Ribble Valley Borough Council  
Church Walk,  
Clitheroe,  
BB7 2RA

Phone: 0300 123 6780  
Email: [lhscustomerservice@lancashire.gov.uk](mailto:lhscustomerservice@lancashire.gov.uk)  
Your ref:  
Our ref: LHS/CS/3/2016/0079  
Date: 10<sup>th</sup> February 2016

<b>Proposal:</b>	Extension to existing building to create a cattery and stables, construction of manege, midden and access arrangements. Resubmission of planning application 3/2015/0571.
<b>Location:</b>	Four Acres Pendleton Road Wiswell BB7 9BZ
<b>Grid Ref:</b>	374791 - 437678

Proposed Site Plan

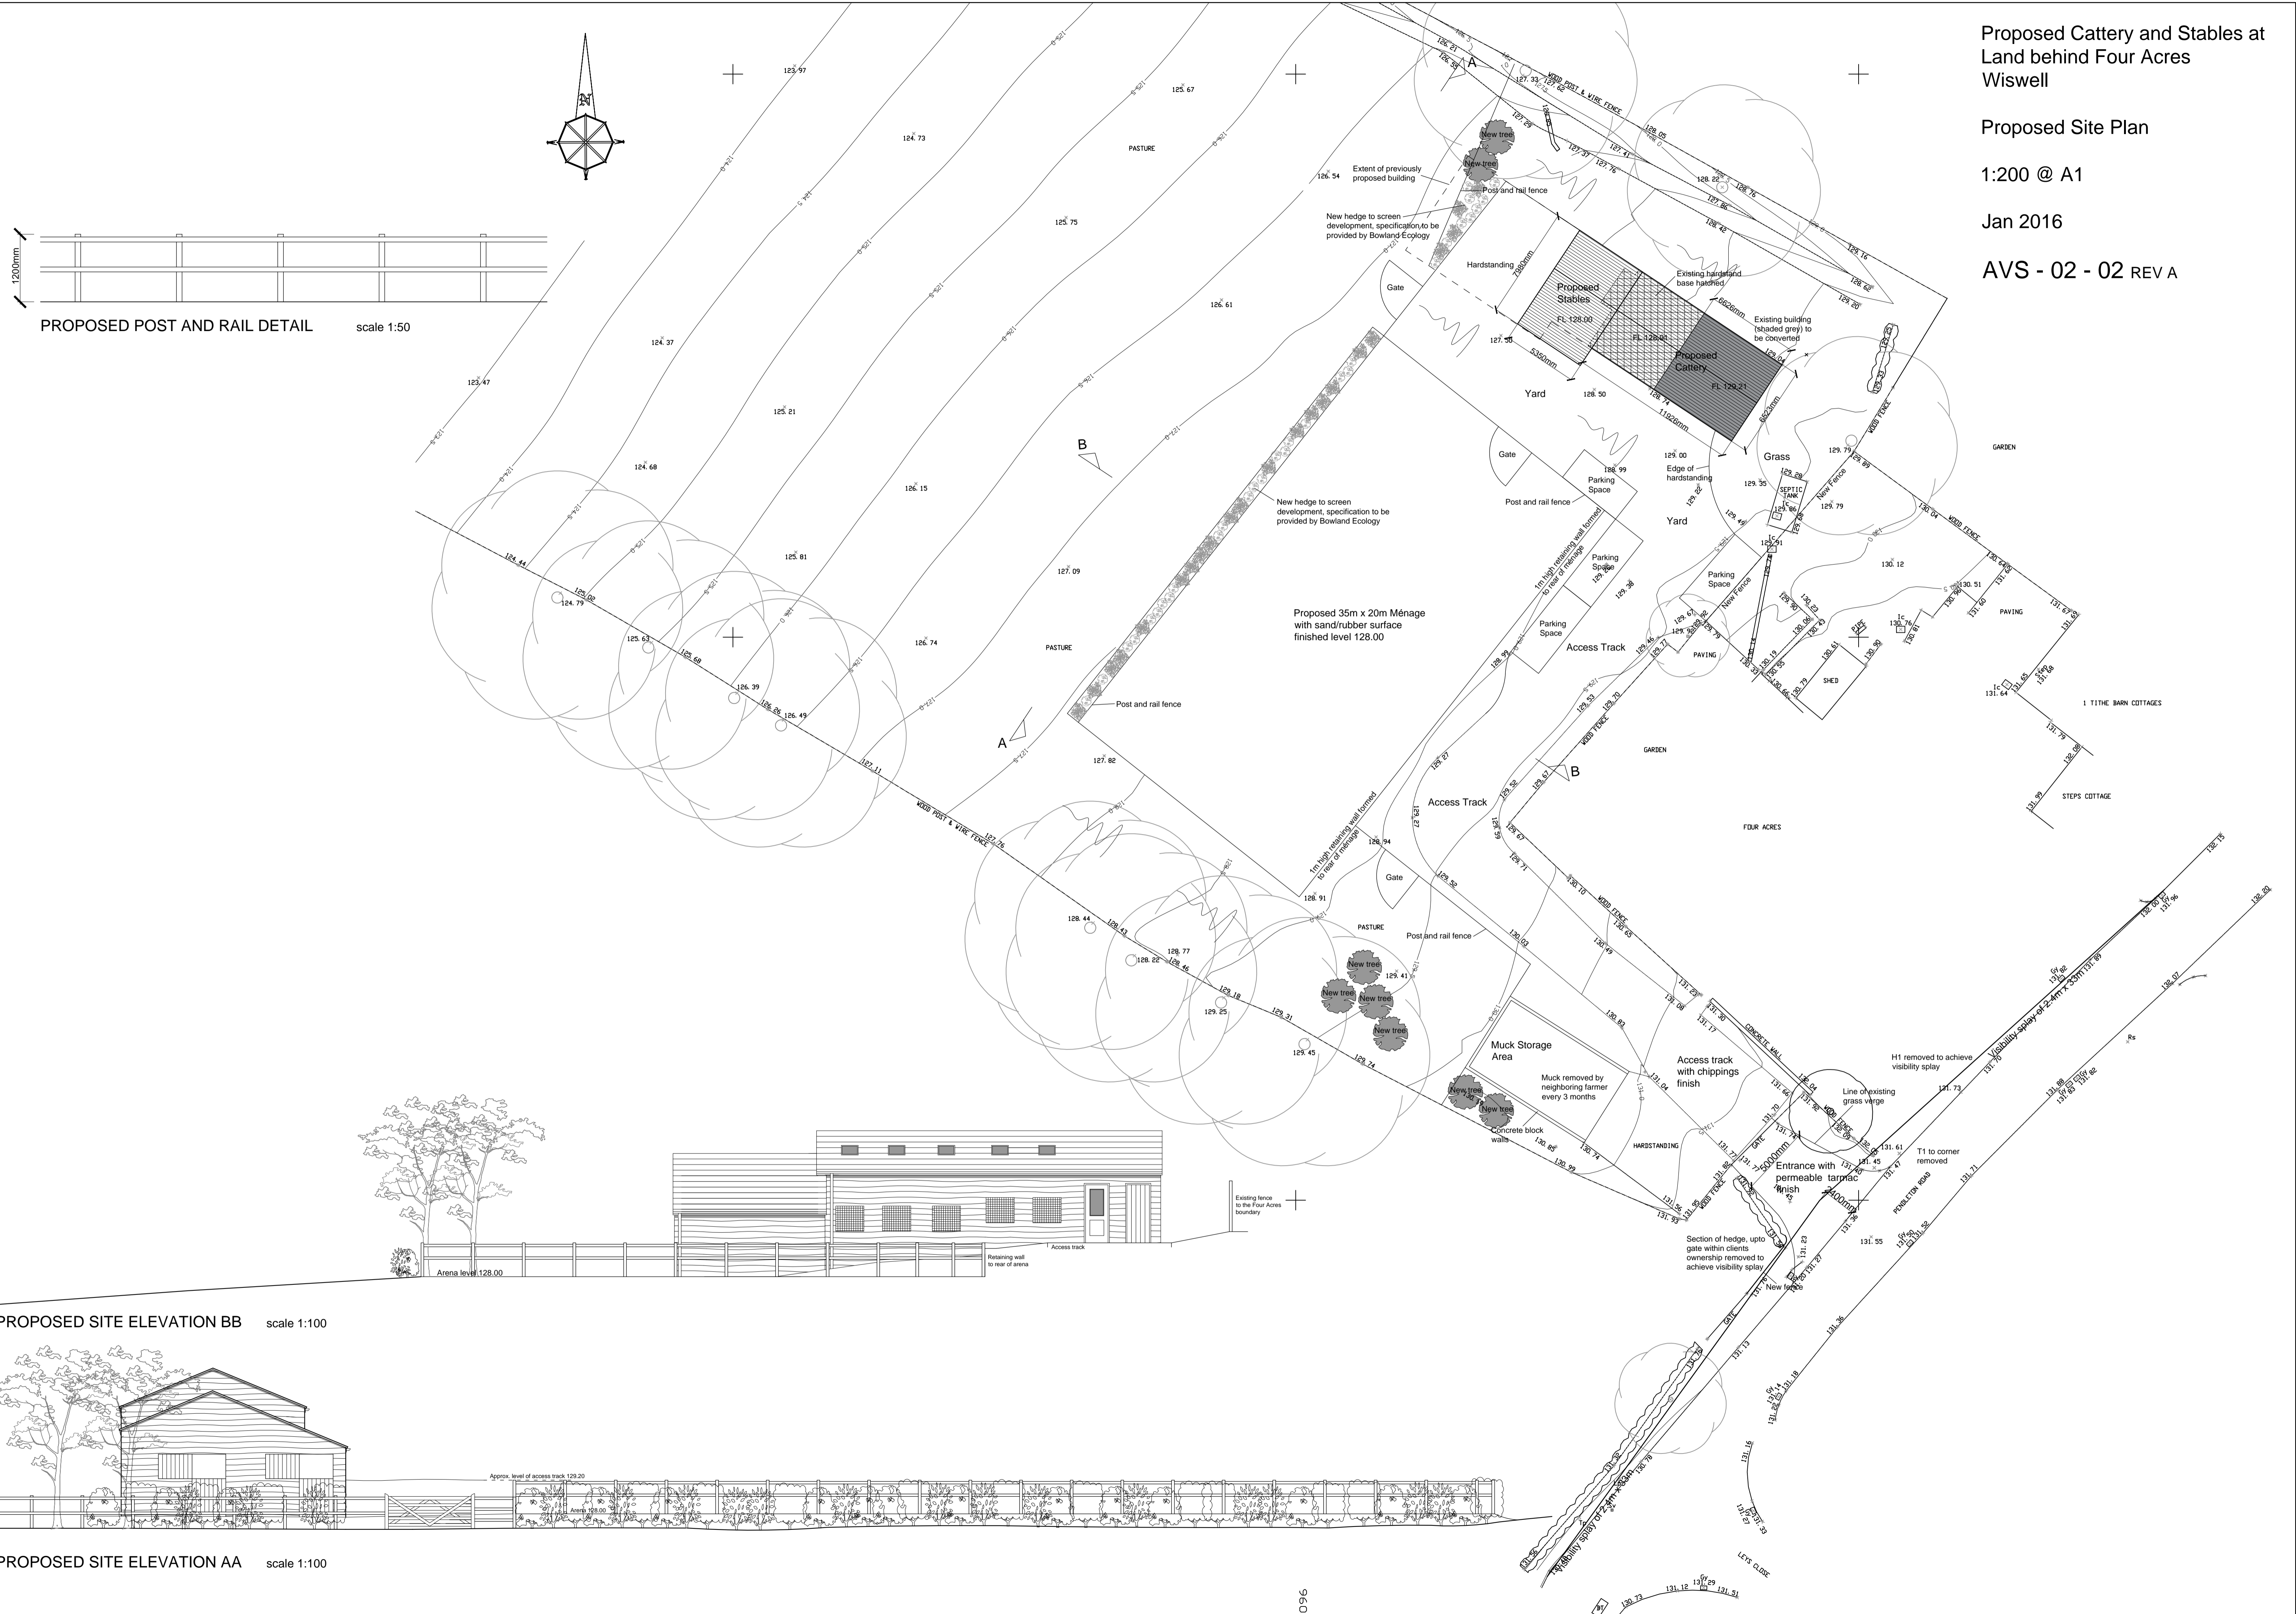
1. No part of the development shall be commenced the visibility splays measuring 2.4 metres by 33 metres in both directions to be provided, measured along the centre line of the proposed new road from the continuation of the nearer edge of the existing carriageway of Pendleton Road, to the satisfaction of the Local Planning Authority. The land within these splays shall be maintained thereafter, free from obstructions such as walls, fences, trees, hedges, shrubs, ground growth or other structures within the splays in excess of 1.0 metre in height above the height at the centre line of the adjacent carriageway.  
Reason: To ensure adequate visibility at the street junction or site access in the interest of highway safety in accordance with Quality of Development Policy and Transport Policy in the Local Plan.

2. The car parking and manoeuvring scheme to be marked out in accordance with the approved plan, before the use of the premises hereby permitted becomes

operative and permanently maintained thereafter. Reason: To allow for the effective use of the parking areas.
